Further Drainage Consultation Comments

Subject: RE: Vistry - Burndell Rd - Pumping

APPENDIX D – Extent of Ditch Regrading 18-070/232A

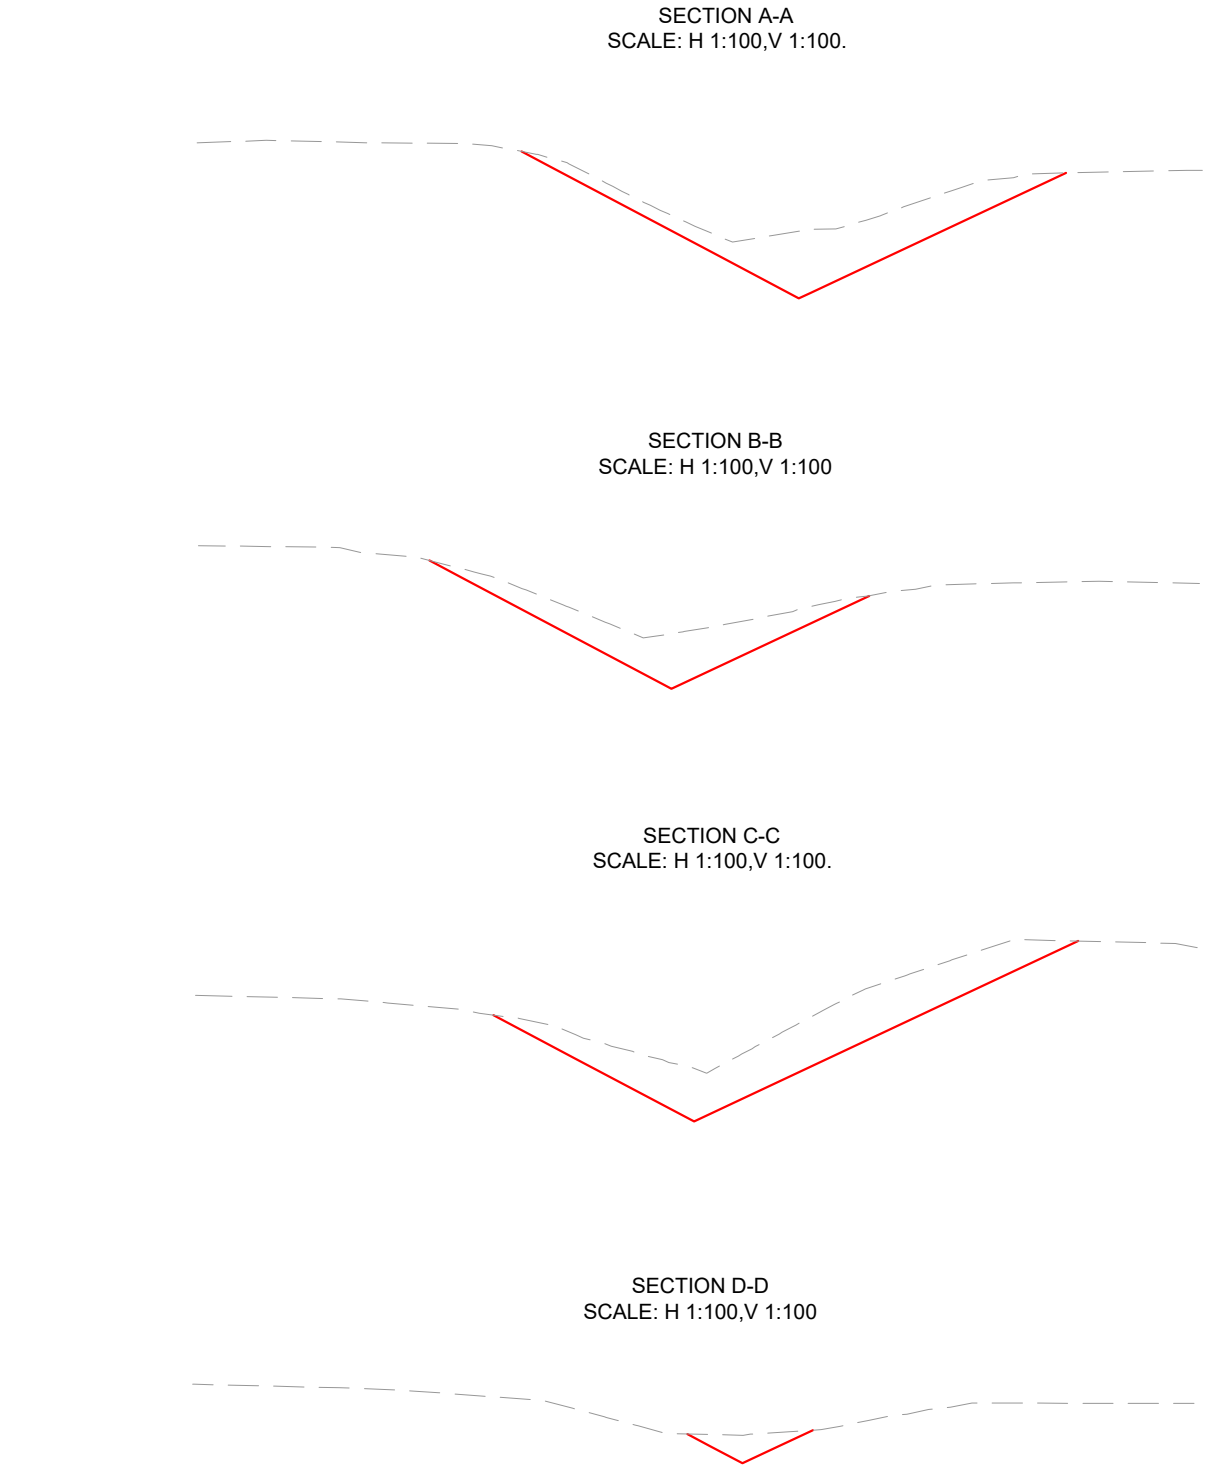
I have now been sent their revised Technical Note. They state that it has updated section 3.5.2 and added an appendix D plan to show the extent of ditch regrading works which would be necessary to the eastern ditch if proceeding with that option. This plan isn't quite what I was seeking as I wanted it to also show the

built layout of the Crayfern site so it was clear what impact there would be on their layout, plus indication of what trees would be affected (although there are trees indicated on the topo).

I will need to talk to Karl again but could you review the amended bit/new plan and advise if you have any concerns with what they are saying.
